**Mosman High School Upgrade (SSD-10465)  
Response to Submissions**

## Attachment 1

Figure 1 – Proposed Building Set Out Plan

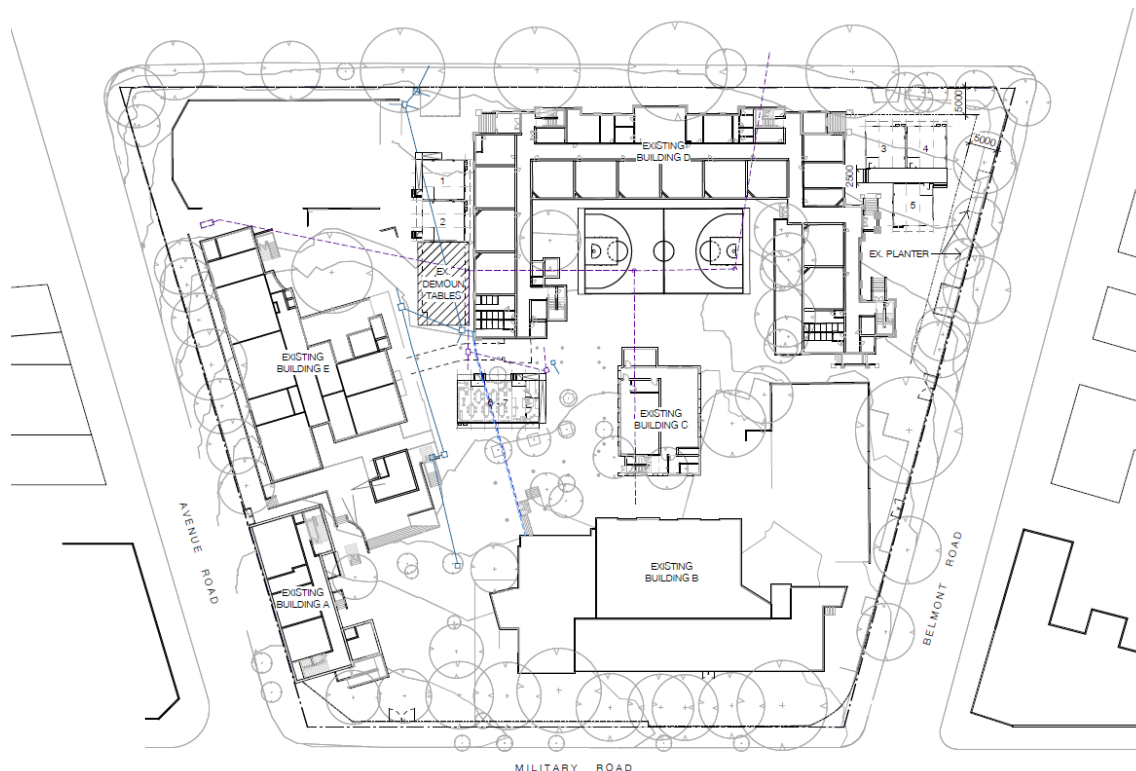
- A summary of works approved as part of the REF, particularly in relation to the ongoing use of the school for both school and community purposes.
- Clarification on the number of permanent buildings at the site and the number of demountable buildings (current and anticipated during construction). These should be clearly labelled on a diagram.
